Crow Trees Farm, Crow Trees Brow, Chatburn, BB7 4AA

Section 96 Application – Non-Material Amendment pursuant to Planning Permission 3/2022/0966

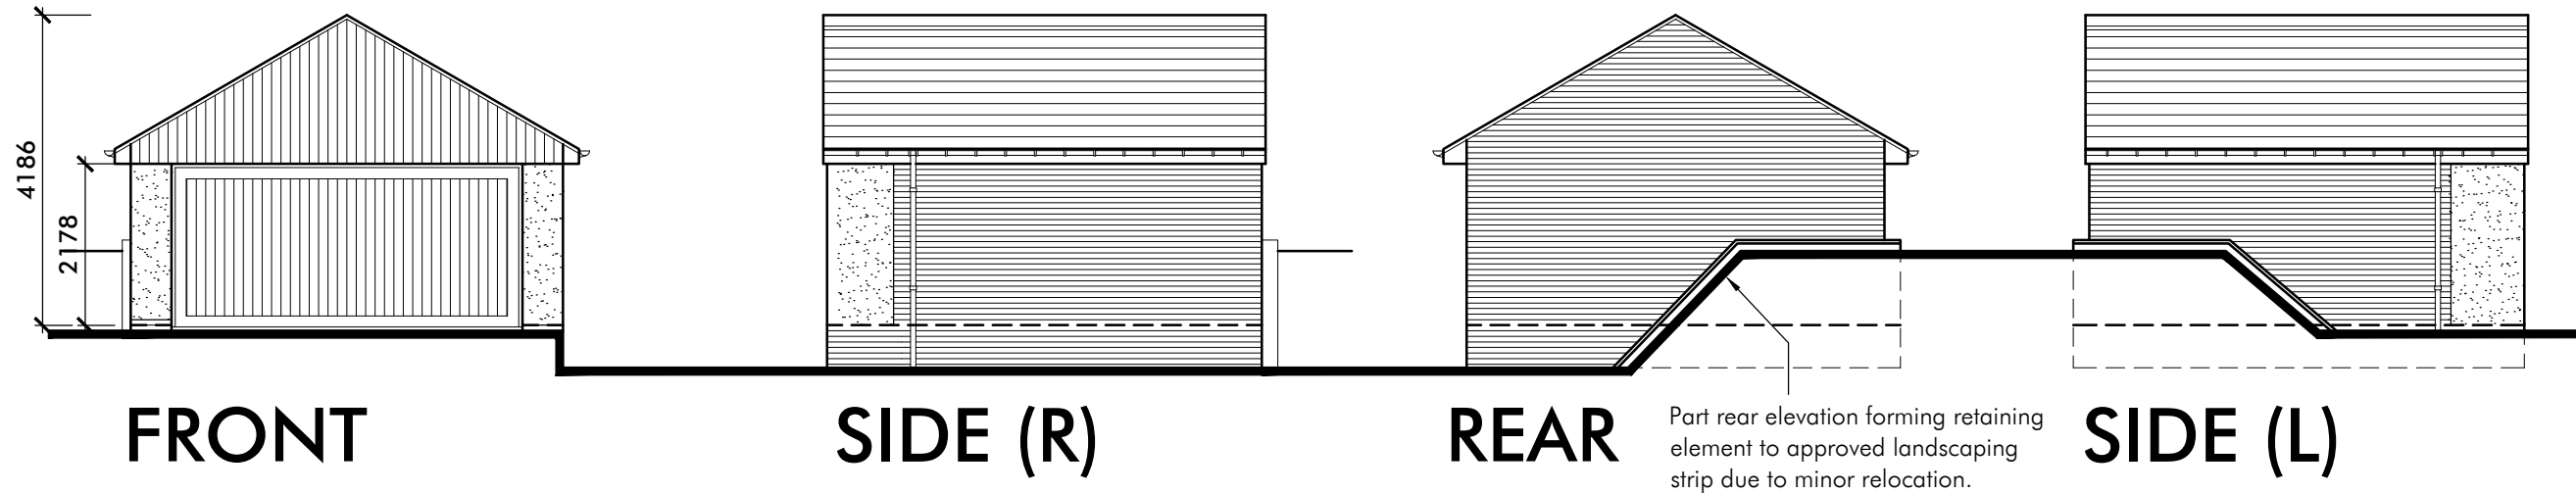
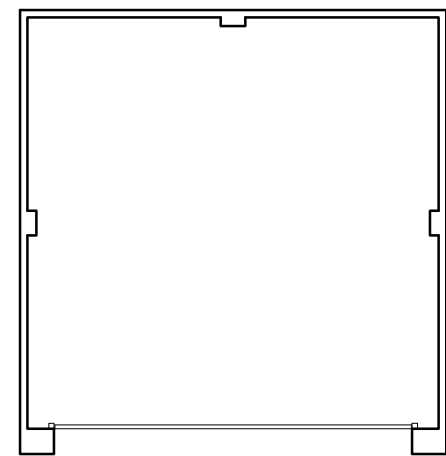
- garden room rear elevation window removed and left end elevation window size minor alterations and ribble blue brick added at low level to DPC
- garage – siting and elevation material amendments

- garage location re-positioned 1m to the south into the driveway area for improved car access/ maneuvering (this moves the garage further away from the boundary with the neighbouring property to the north)

- main materials altered to ribble smooth blue brick (specification image provided on the plan) with white chalk render to the front elevation. Part of the rear elevation also to form a retaining element to the garden area to rear (due to the minor relocation)

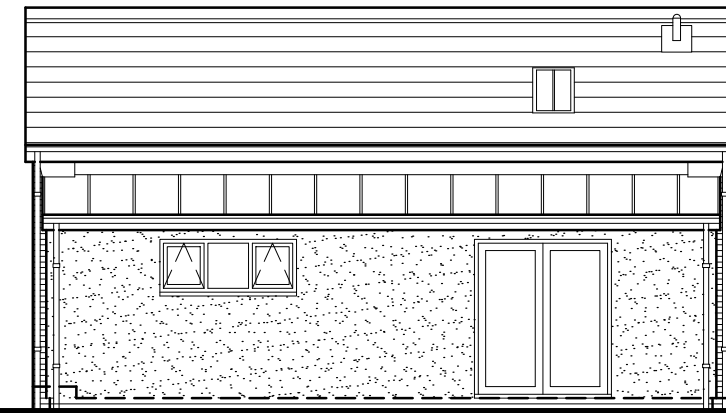
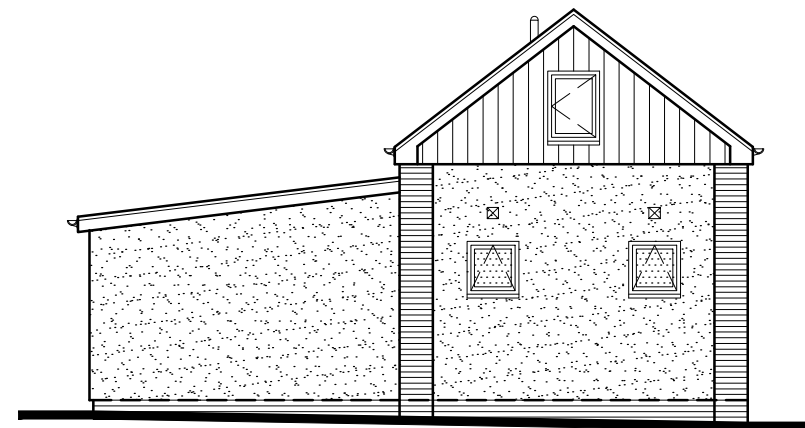
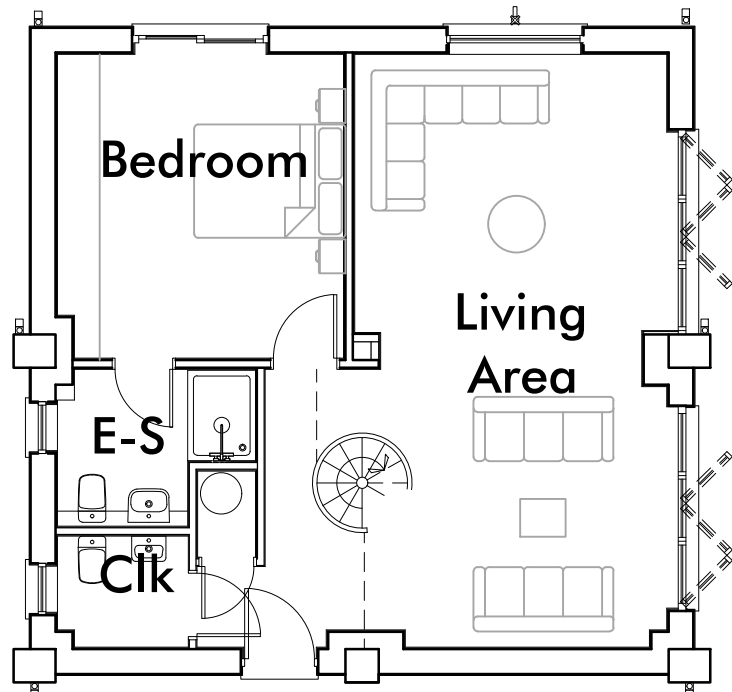
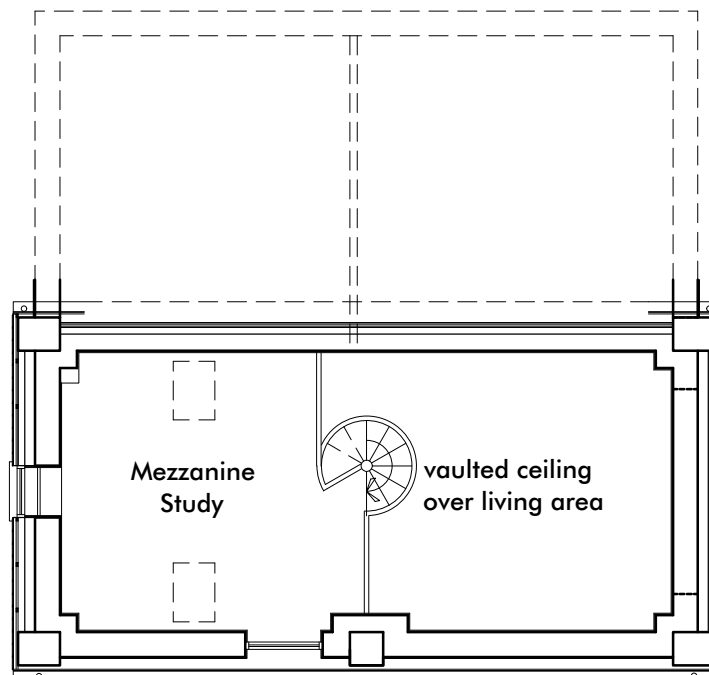
- ancillary building - elevation material amendments
 - material altered to white chalk render with smaller area of cladding
 - minor revision to door location
